Sheringham Shoal and Dudgeon Offshore Wind Farm Extension Projects

The Applicant's Comments on the Maritime and
Coastguard Agency's Deadline 7 Submission

Document Reference: 22.25

Title: Offshore Works Plans

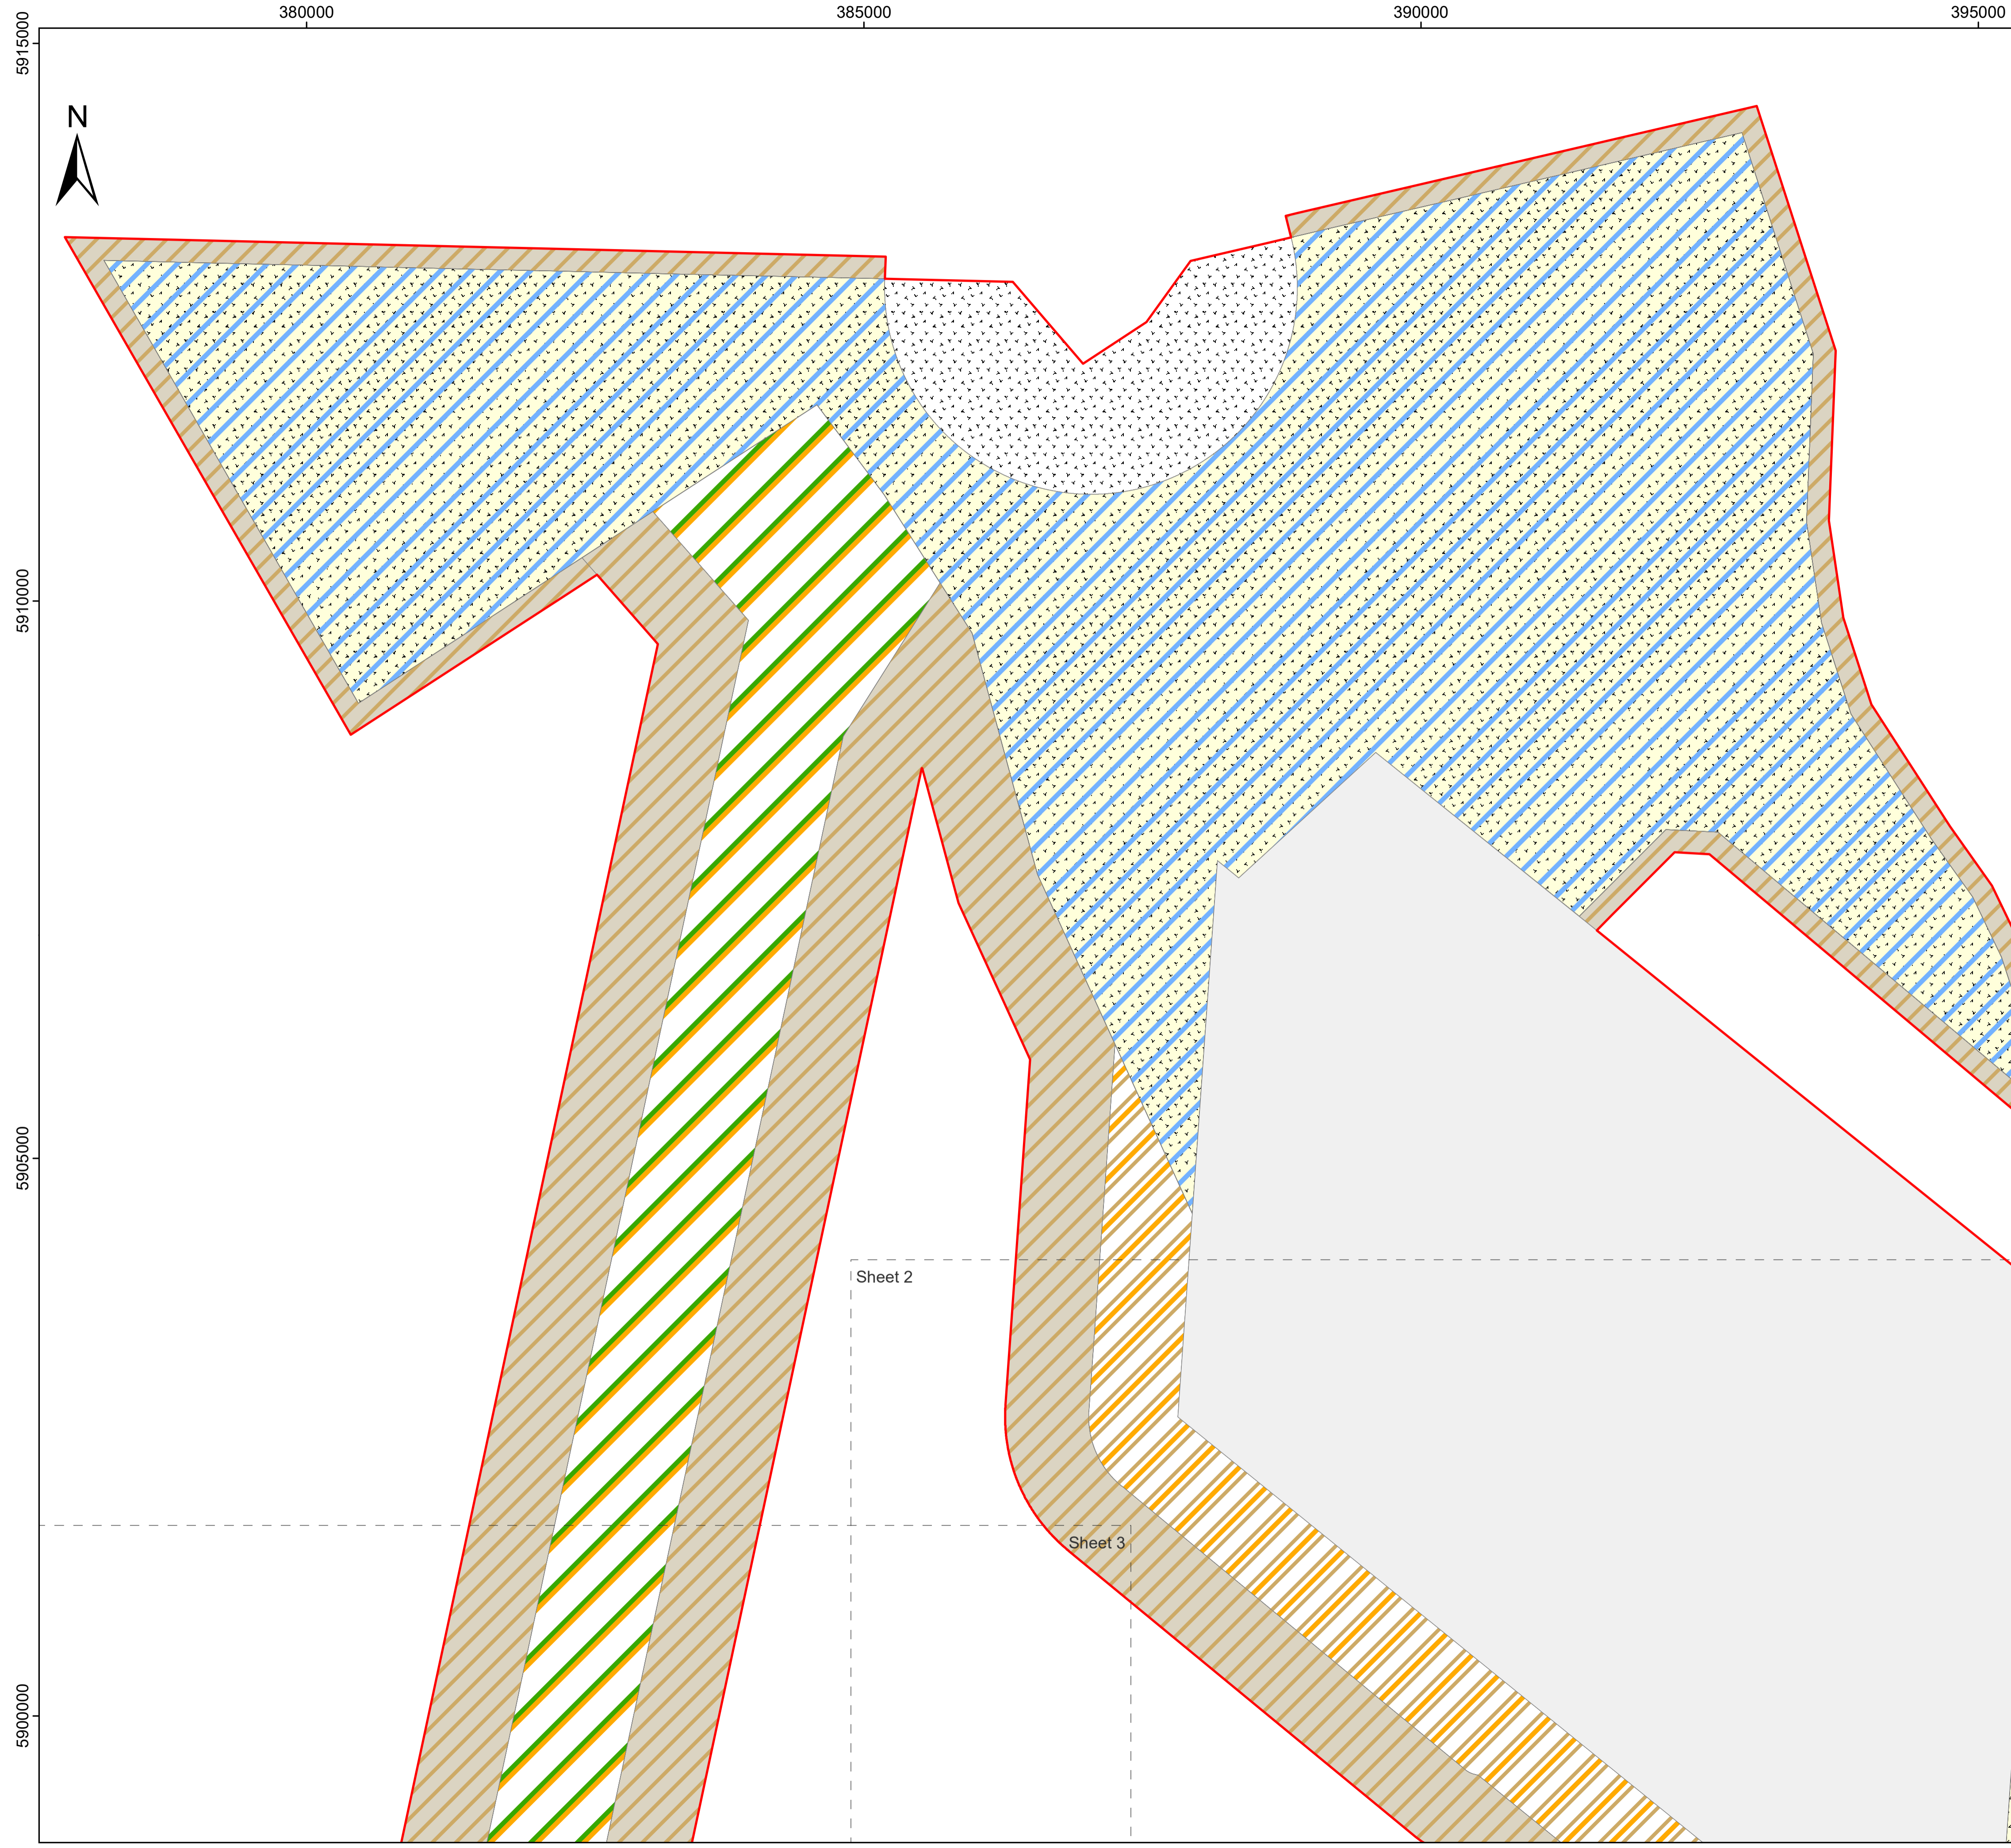
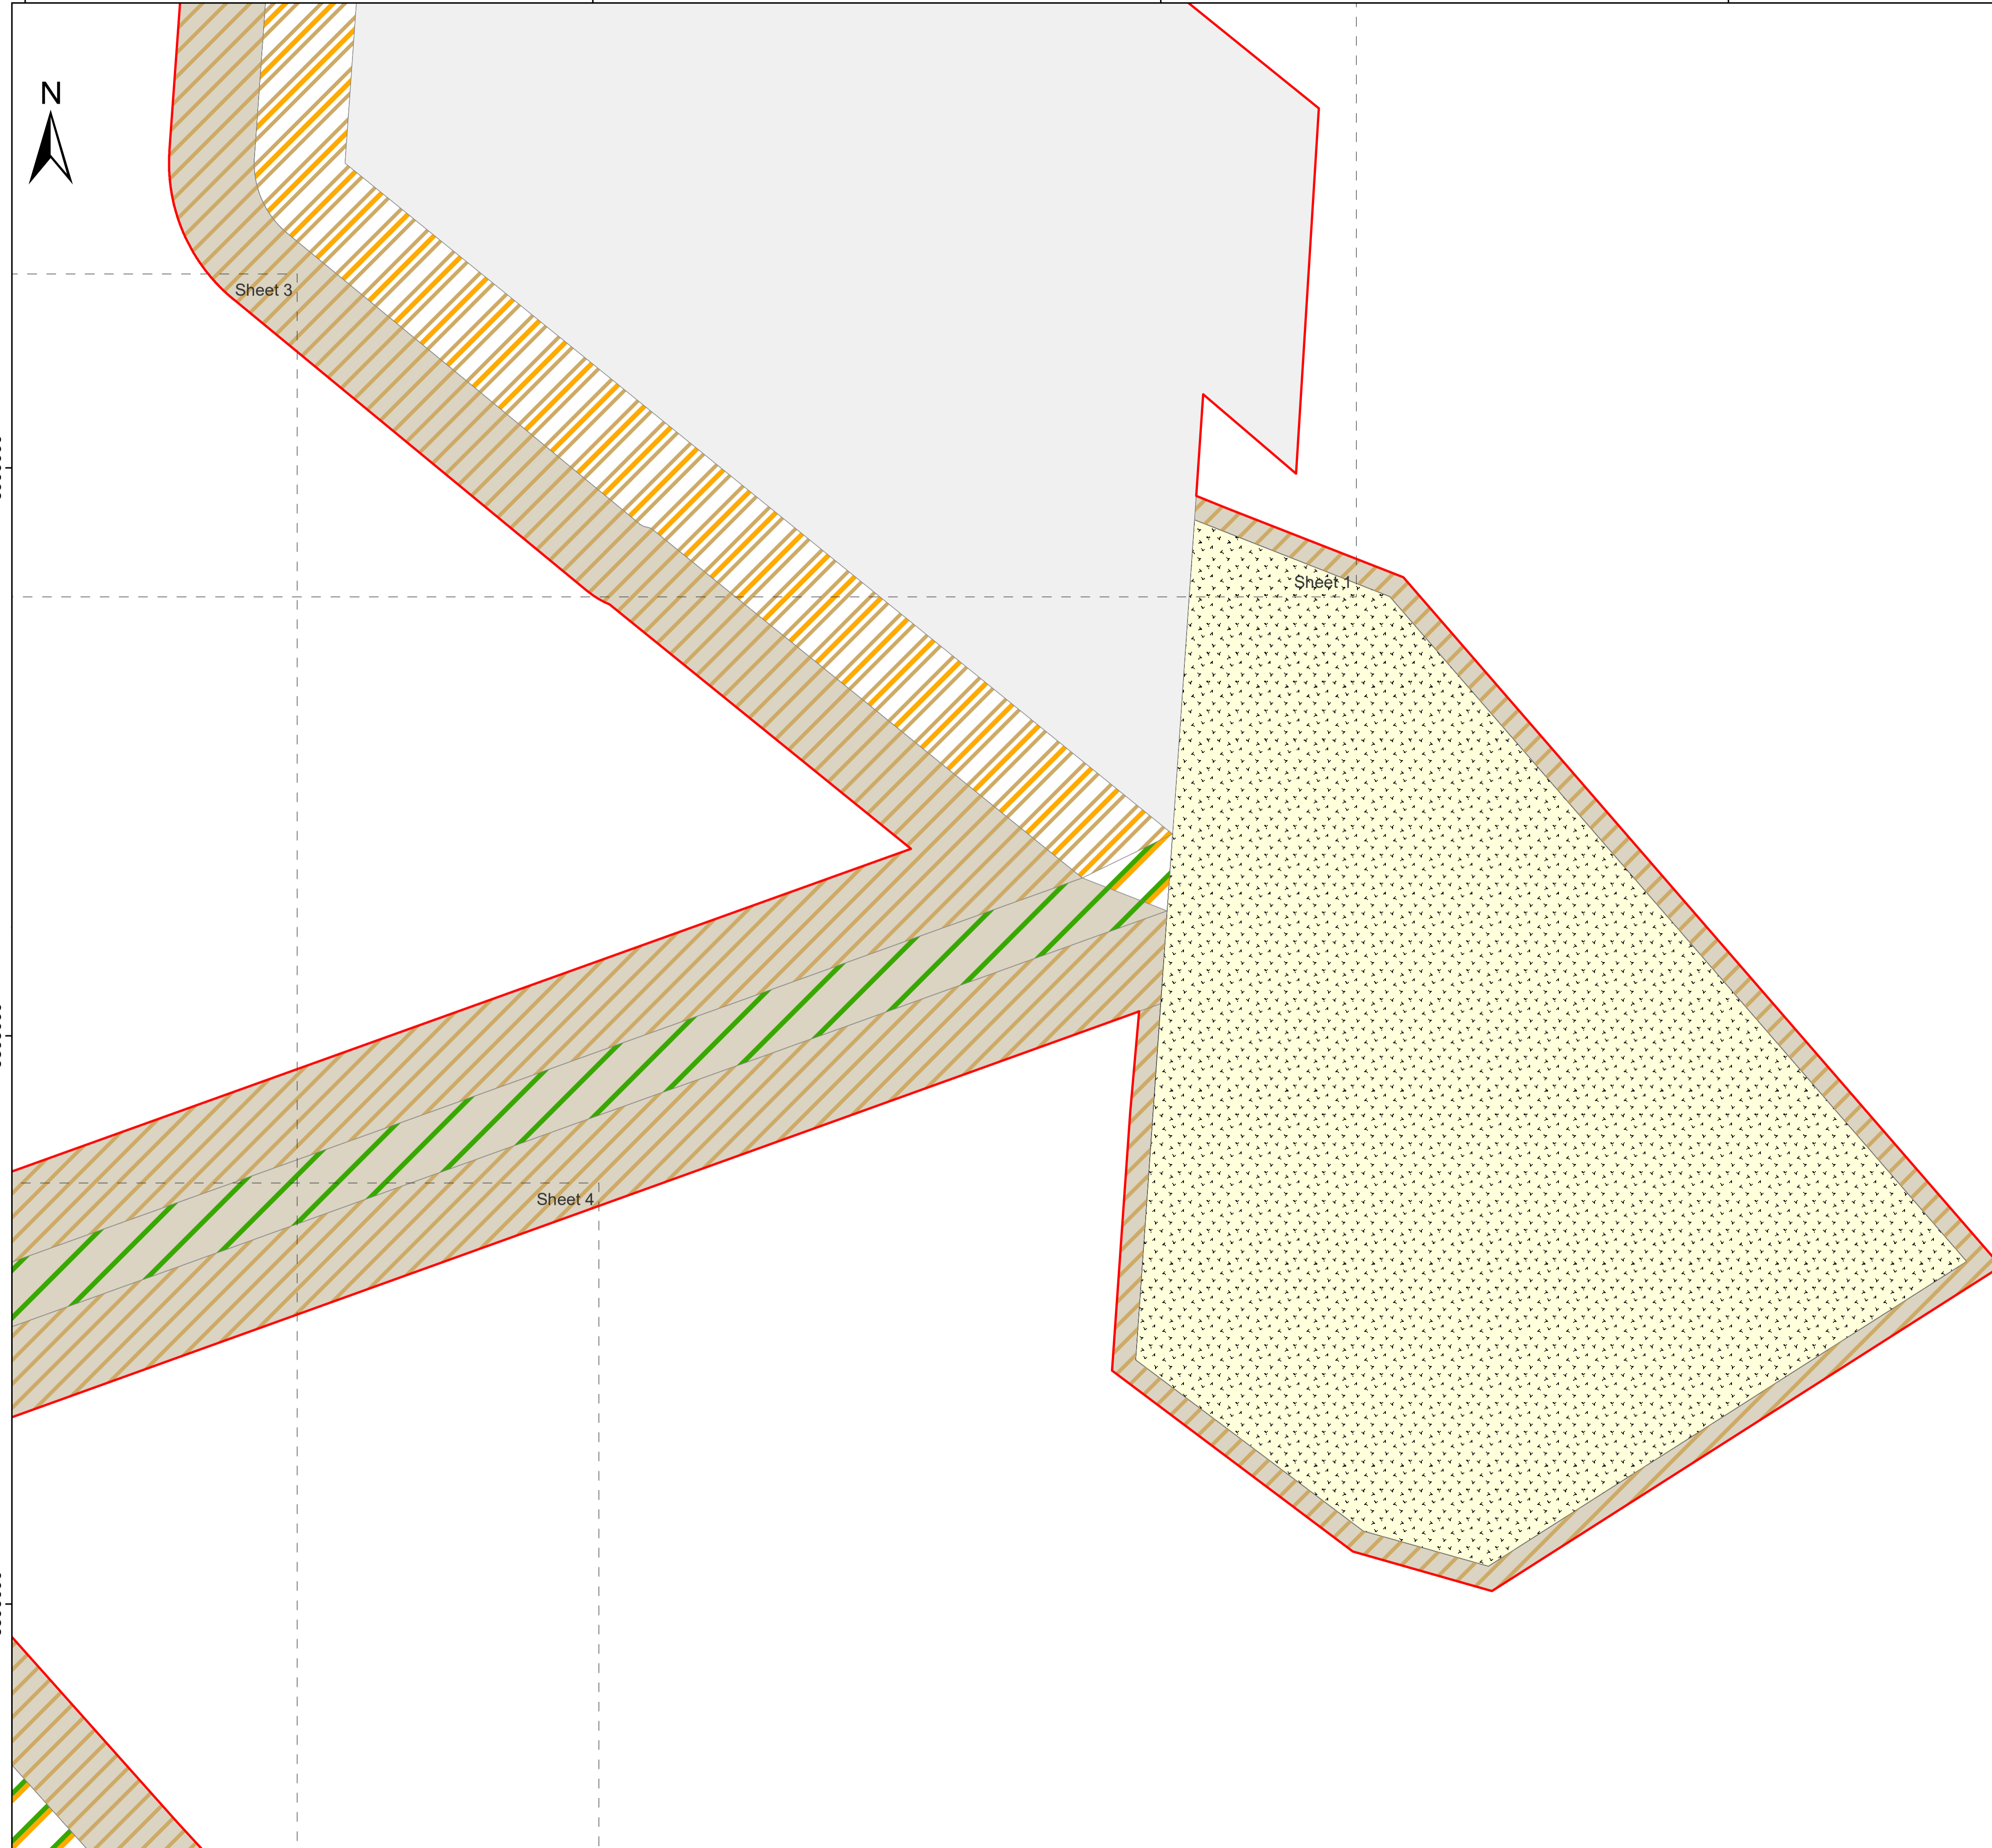
ID	Question	Maritime and Coastguard Agency Responses	Applicant's Comment
	<p>a) Applicant and MCA, show this exclusion zone on a map/diagram with an easily recognisable title.</p>	 <p>Figure 1 Recommended 'exclusion area' (blue hatched area) or reduction in f</p>	
	<p>b) In its post Examination considerations, if the ExA considers it is essential to include a provision for an infrastructure free zone in line with MCA's representations (as outlined in Section 7 and Figure 2 (Recommended Boundary Amendment) of their submission at Deadline 5) [REP5-081], Applicant and MCA advise if the map/diagram would need to be included as a certified document or if it should be included in the ES or the Offshore Project Environmental Management Plan.</p>	<p>MCA would suggest that the image showing the 'exclusion area' is referenced in the DCO as a certified document and included in pre-construction plans and documentation.</p>	<p>It is the Applicant's view that, should it be deemed essential by the Secretary of State to include provision for a surface structure free area then this would be most appropriately secured via the Offshore Works Plans without need to certify the attached figure or have it included in any other post consent documentation. See the response to Q4.19.1.6c of The Applicant's Responses to the Examining Authority's Fourth Written Questions [document reference 21.5] and the Works Plans (Offshore) (Without Prejudice) (Revision B) [document reference 2.7.2].</p>

<p>c) Applicant and MCA, provide dDCO drafting, be it a new article, new</p>	<p>MCA would suggest that latitude and longitude coordinates of the 'exclusion area' are included</p>	<p>The most straightforward mechanism to secure a surface structures free area within the Order Limits at DEP North</p>

ID	Question	Maritime and Coastguard Agency Responses	Applicant's Comment															
	<p>requirement or amendment to an existing requirement, and any relevant definitions that puts the exclusion zone into effect.</p>	<p>in the DCO, for example: None of the infrastructure listed in Work No.*** may be installed within the area defined by the coordinates as specified below and no part of any wind turbine generator, including its blades, may overfly into the area:</p>

ID	Question	Maritime and Coastguard Agency Responses	Applicant's Comment
			<p>ALARP Statement</p> <p>The MCA state they <i>'must ensure that the risks to vessels remain tolerable (if ALARP) or acceptable at all times. It is not acceptable to MCA to say that the risks to vessels are tolerable if, for even a short time, they are exposed to a hazardous area with an unacceptable risk'</i>. The Applicant confirms that all risk (as evidenced by the NRA [APP-198]) are within ALARP parameters i.e. Tolerable (if ALARP) or Broadly Acceptable.</p> <p>Finally the Applicant has agreed final SoCGs with Trinity House [document reference 12.19] and the UK Chamber of Shipping [document reference 14.22] regarding the ALARP statement and whilst the Chamber advocates for more sea room their disagreement of impacts is not material to the in-isolation impacts significance as assessed by the Applicant.</p>
Q4.19.1.6	<p>Without prejudice mitigation wording</p> <p>At ISH7 [EV-096] [EV-100] it was suggested that a potential mitigation would be an exclusion of wind turbines and any other associated infrastructure from an area in between and to the west of the Mid-Outer Dowsing buoy and Dudgeon buoy, thus allowing greater sea room. The ExA acknowledges that the Applicant strongly opposes this measure and would not wish it to be proposed. Nonetheless, to aid the ExA's understanding of the possibilities before it, and to inform the SoS's decision, provide the following information without prejudice:</p>	<p>The image below (Figure 1) shows MCA's recommended 'exclusion area' or reduction to the red line boundary:</p>	<p>Noted.</p> <p>The Applicant refers to The Applicant's Comments on Maritime and Coastguard Agency Deadline 6 Submission [document reference 21.11] and the response to Q4.19.1.6 of The Applicant's Responses to the Examining Authority's Fourth Written Questions [document reference 21.5] which provide its justification for providing the alternative without prejudice surface structures free area.</p> <p>See the Works Plans (Offshore) (Without Prejudice) (Revision B) [document reference 2.7.2].</p>
